CITY OF ALBUQUERQUE

RE: **Beehive Homes**
Grading & Drainage Plan/Report
Engineer's Stamp Date 9-8-2016 (File: E10D027)

Based upon the information provided in your submittal received 9-15-2016, the above referenced Grading and Drainage Plan and Report is approved for Building Permit with the following condition:

SWPP PLAN
SCALE: 1"=20'

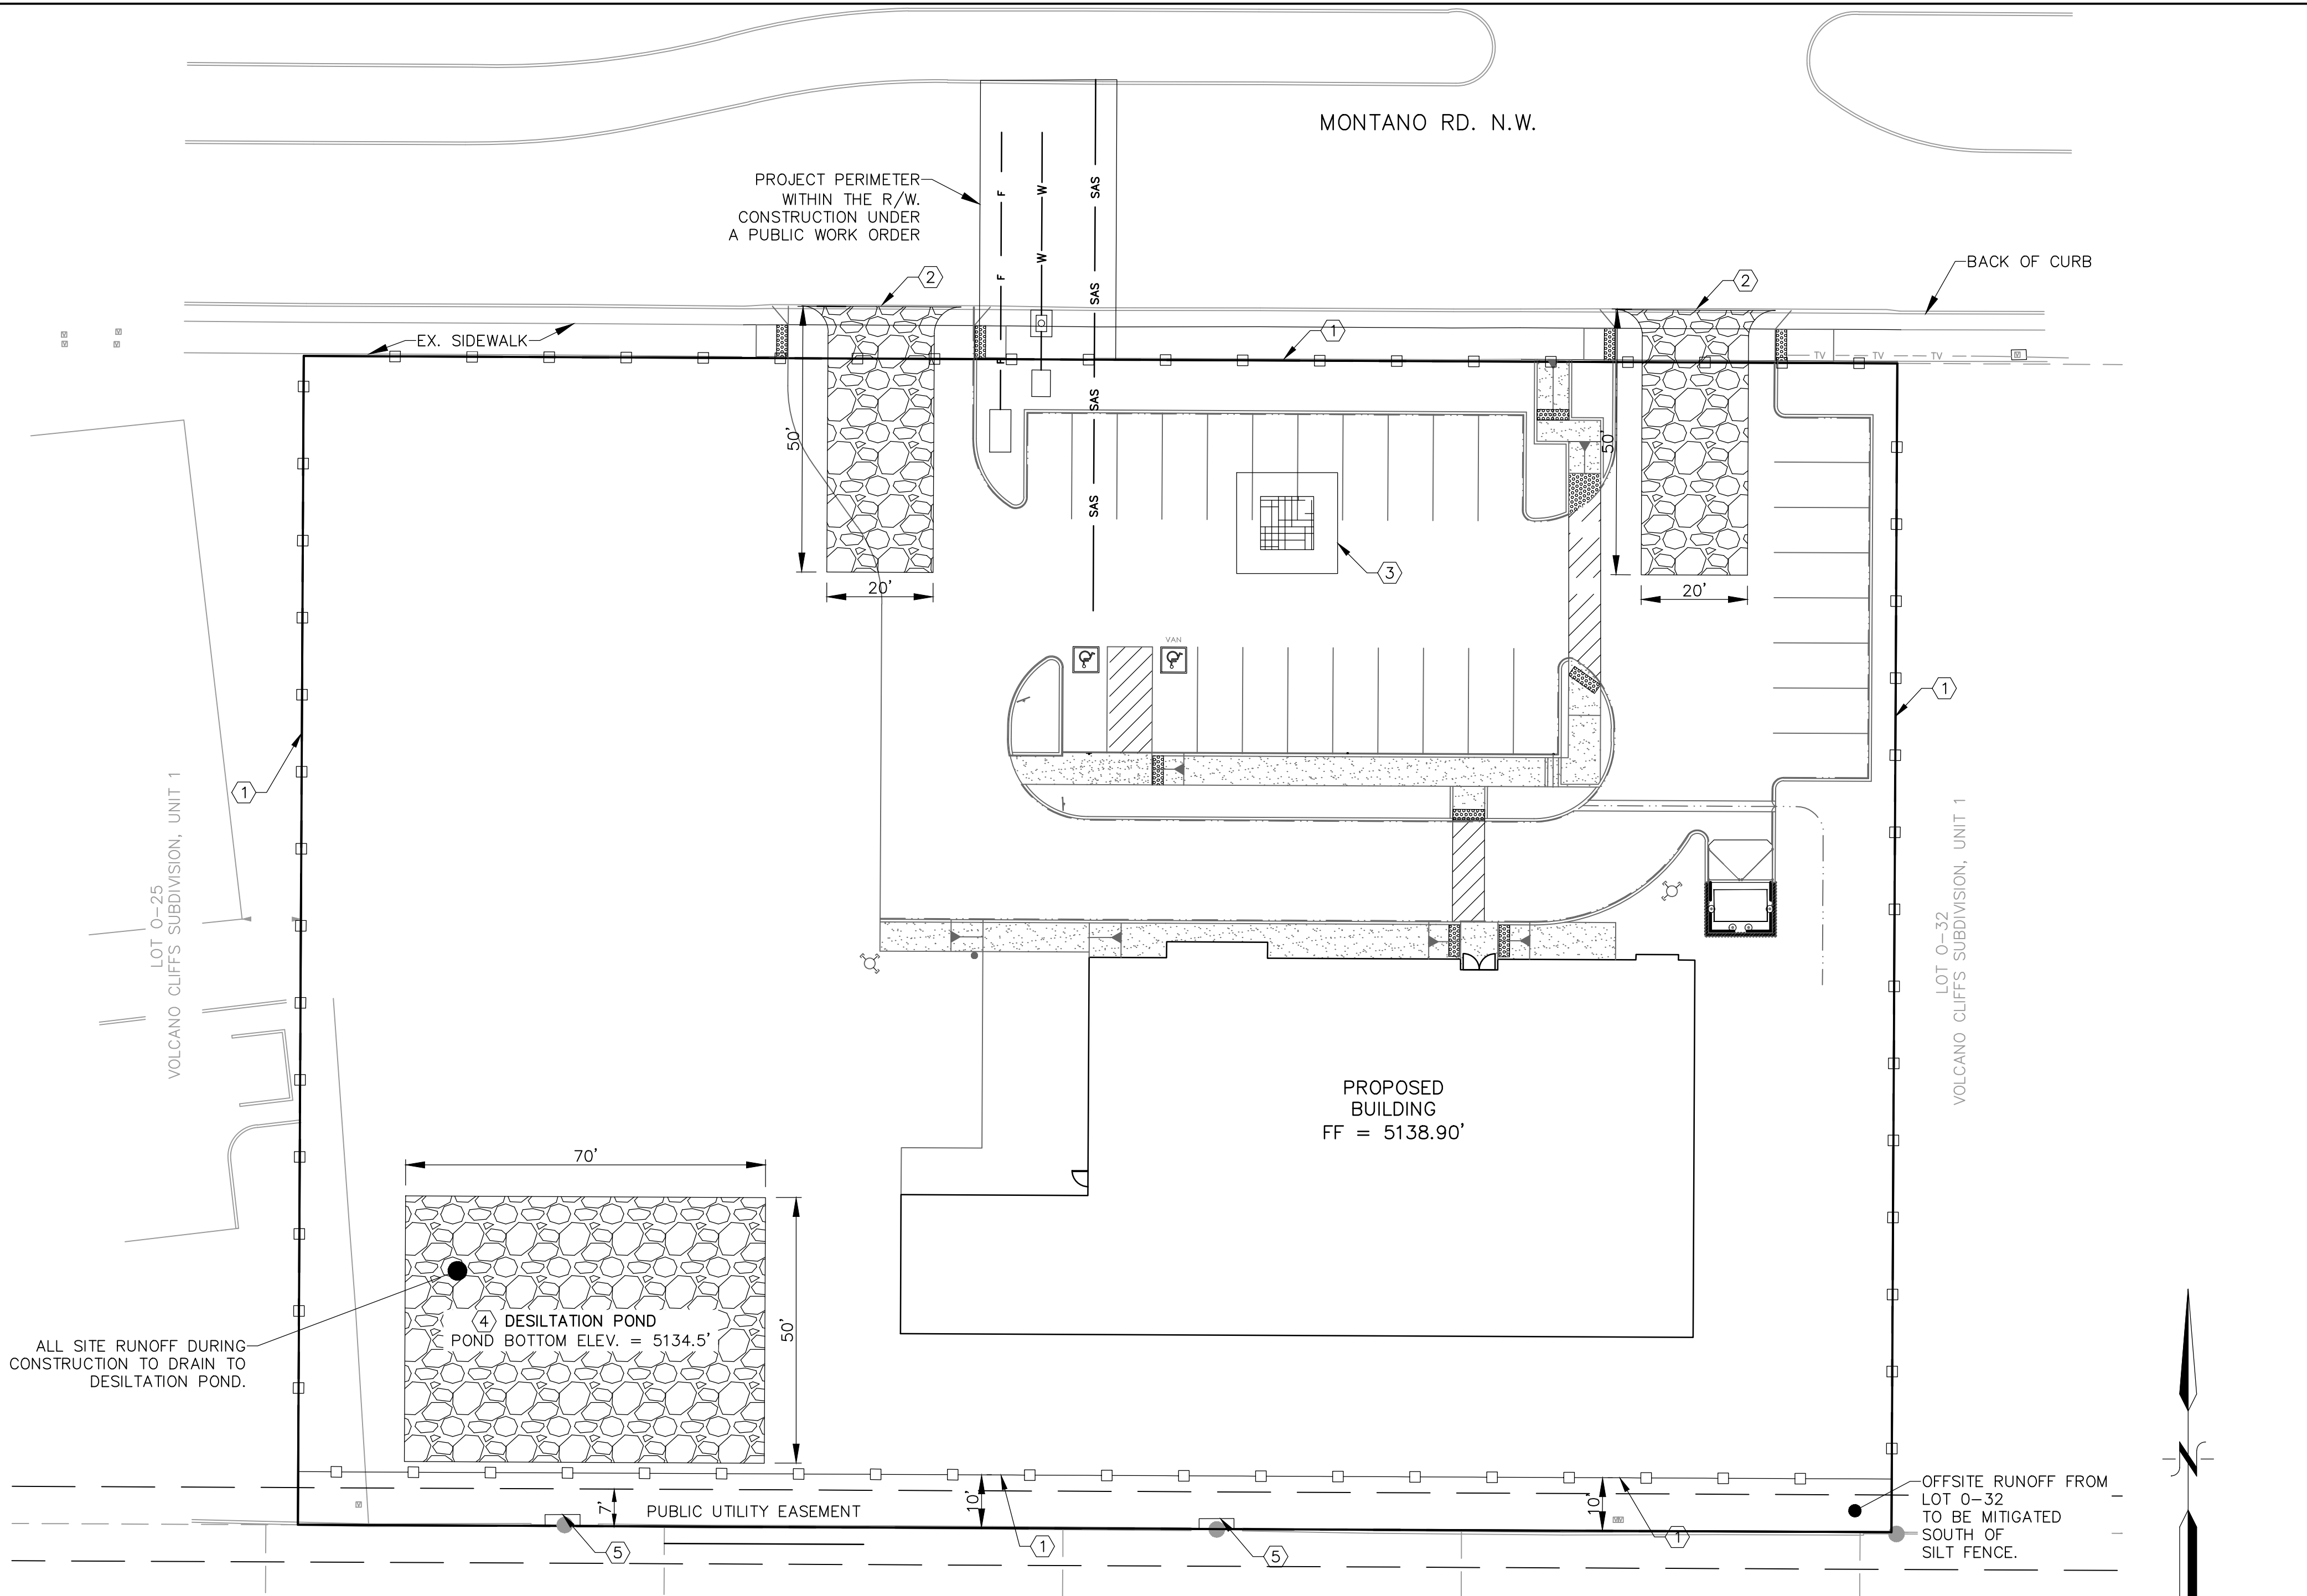
- Provide a desiltation pond, or other method to decrease sediment transport onto the adjacent property, since much of the existing on-site vegetation will be cleared with Phase I.
